Engineers Comments Regarding Surface Water Drainage

Application Reference:	A/44/26/PL	Reviewer Reference:	ADC/EXT5/AF
Planning Officer:	Neil Crowther	Date of Review:	26/08/2026
Site Name:	Former Shrublands Nursery Roundstone Nursery Angmering BN13 4AT		
Application Description:	Retention of 40 No dwellings (after demolition of previous buildings) and associated operations (resubmission following A/115/25/PL). This application is in CIL Zone 2 and is CIL Liable as new dwellings.		
Assessment Number:	4

DRAINAGE (SHEET 1)

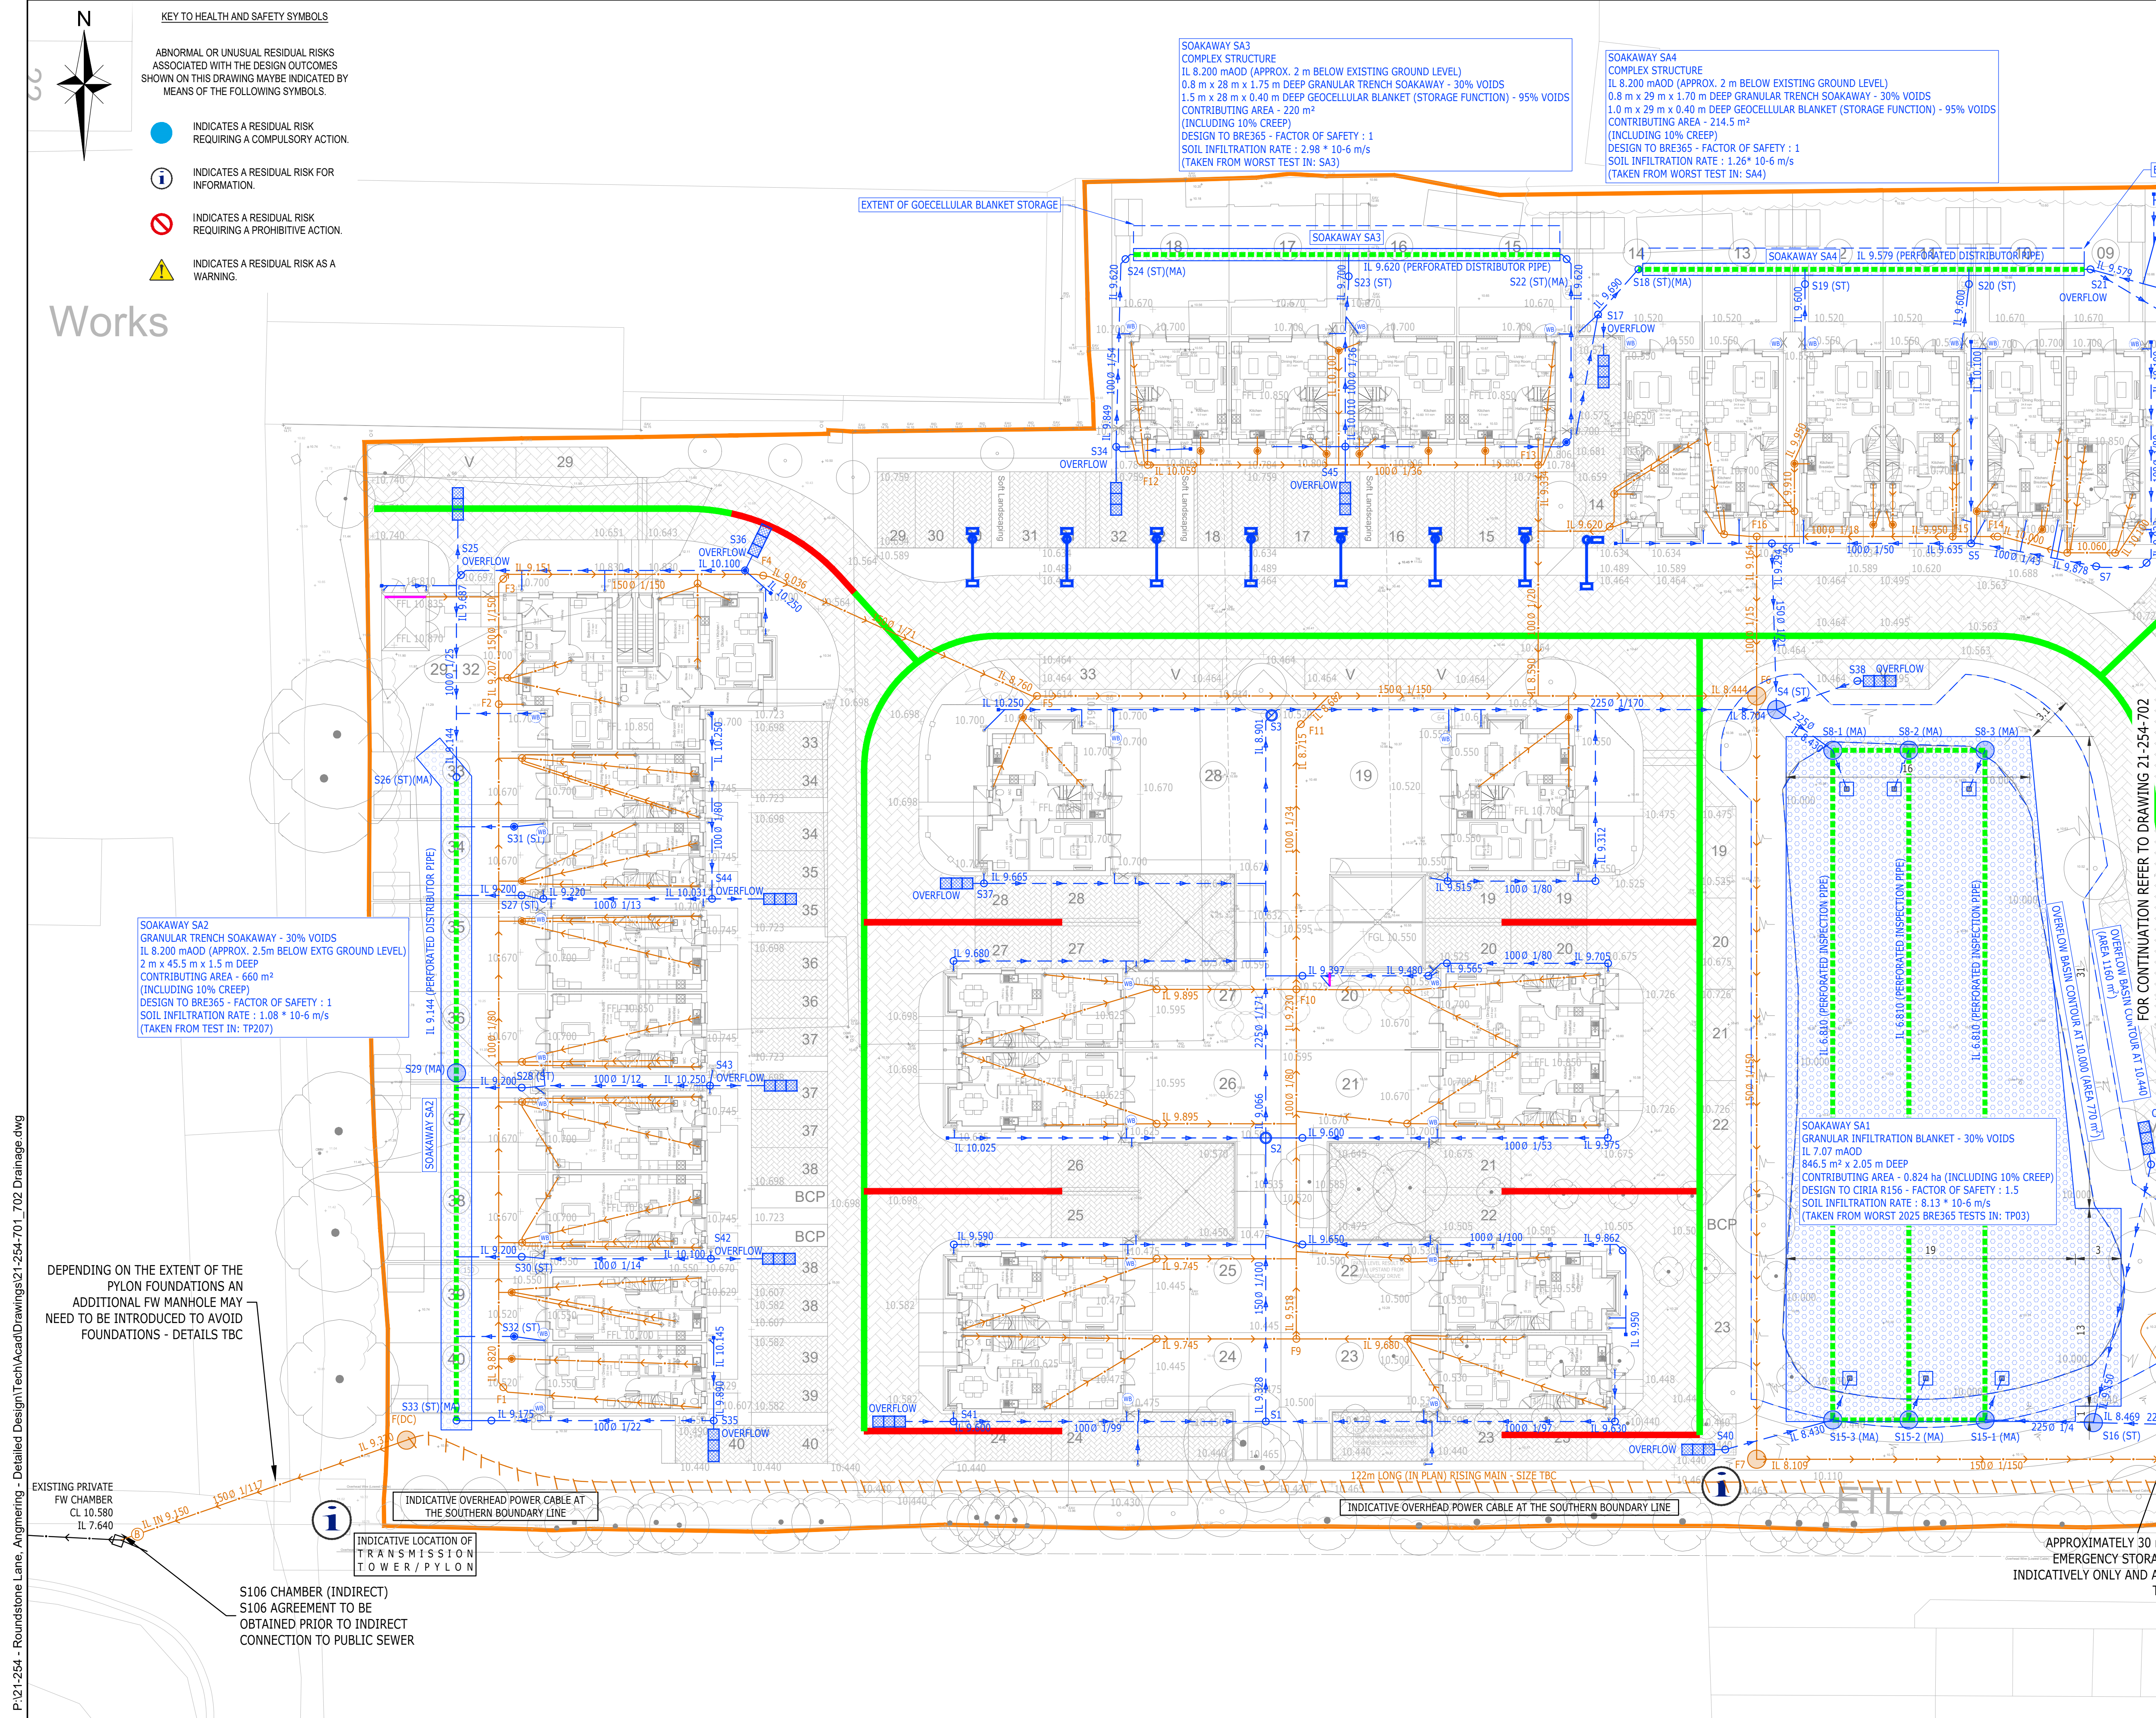
- 0.6. The applicant's design and modelling approach to the remedial works is to connect the existing soakaways and permeable paving together via overflows (piped connections to distribution tanks in the permeable pavement stone layer) such that surface water will drain to the central soakaway (SA1) and fill the soakaway (and a shallow open basin above) prior to flooding from any other part of the linked system. A network drainage model is presented which effectively conveys the entire development's drained area to SA1 and relies entirely upon the infiltration through the base of SA1 and the storage within SA1 (and the basin above) to serve the development. The infiltration and storage provided by the other soakaways and the permeable paving and associated infiltration trenches is disregarded. This is a robust approach and no further hydraulic modelling is required.

- 0.7. The infiltration testing which supports the calculations for SA1 were undertaken at the end of April (2025). BRE DG365 (2016 revision) recommends that testing should be undertaken under worst case conditions (in winter or spring). Our position is that since the groundwater levels during a very wet February (2026) are known to not rise above a metre distance of the base of the proposed soakaway, and the method includes three fills to replicate saturated conditions, that the testing is acceptable with a suitable factor of safety applied in accordance with NSfS clause 3.17. This has now been incorporated and is acceptable.

- 1.3. The lowest soakaway base has been set at 7.07m AOD and we are satisfied that an additional buffer is not required to maintain a vertical discharge of 1 metre above the high ground water level.

- 3.1. The remedial designs are accompanied by drainage calculations which show that based upon the parameters and infiltration rates used, the system does not flood during the design storm.
- 3.2. The infiltration testing for soakaway SA1 includes a range of results and the designer has correctly selected the worst case, being 8.13×10^{-6} . Modelling is now provided with a factor of safety applied to the soakaway design of 5, which is acceptable for the circumstances. As a base draining

soakaway the correct design standard is Ciria 156 for which the NSfS requires this level of FoS. It is noted that minor flooding at the head of one of the runs (pipe ref 7.000) is predicted during the 15 minute summer design storm. This is acceptable in the basis of omitted chambers and pipes extant in the design together with the infiltration potential in the permeable paving and other soakaways which is omitted following a precautionary approach.

Job Title	FORMER SHRUBLANDS NURSERY ROUNDSTONE LANE, ANGMERING				
Drawing Title	DRAINAGE (SHEET 2)				
Client	SIGMA HOMES				
Scale	1:200 @A1	Date	JUL 2025	Designed	AK
Drawn	AK	Checked	BO	Approved	BAC
Job No	21-254	Drawing No	21-254-702	Rev	H

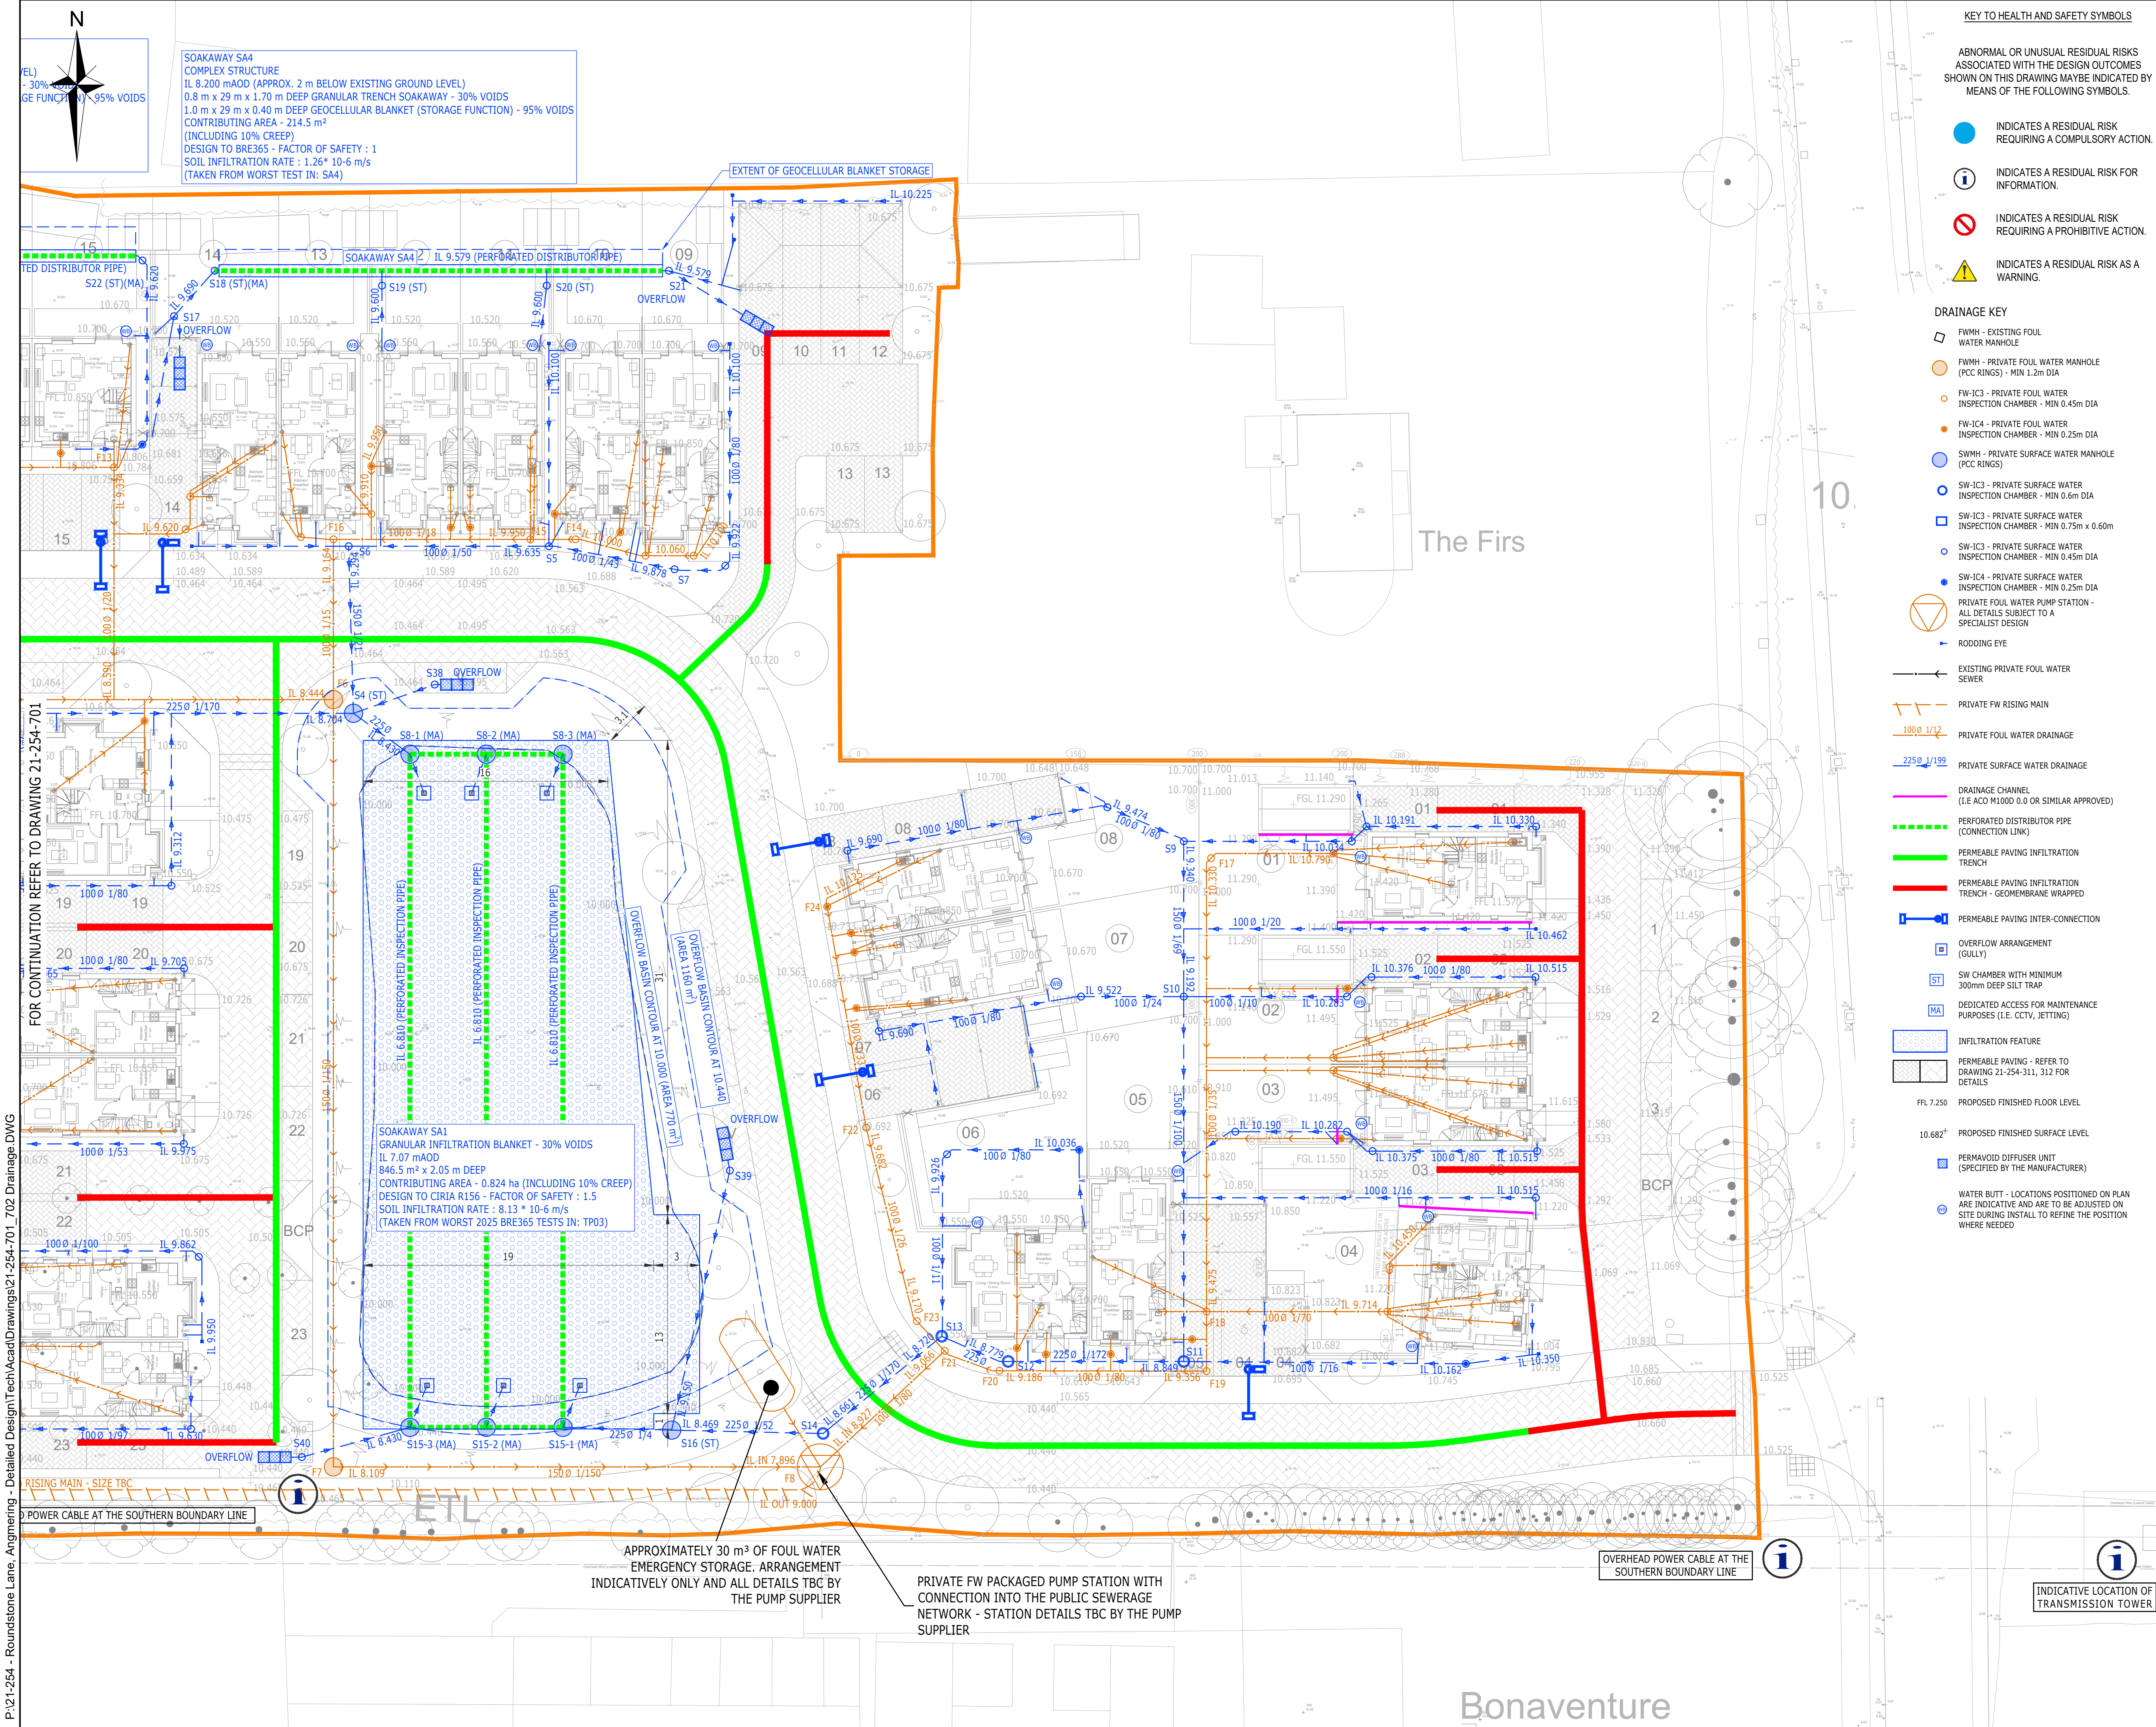
- 3.3. The network model includes the permeable pavement together with SA2, SA3 and SA4 without any information coefficient. SA2, SA3 and SA4 are also modelled to have almost no volume capacity (1%). The calculations demonstrate that flows from the catchments draining to these soakaways can be conveyed to SA1. The infiltration potential from SA2, SA3, SA4 and the permeable paving therefore becomes an additional factor of safety.
- 3.4. A technical design has been provided including finished levels plans, construction details, drainage schedules and an update to the detailed Management and Maintenance Plan. The technical design is acceptable and the design documents are noted above in the list of approved documents.
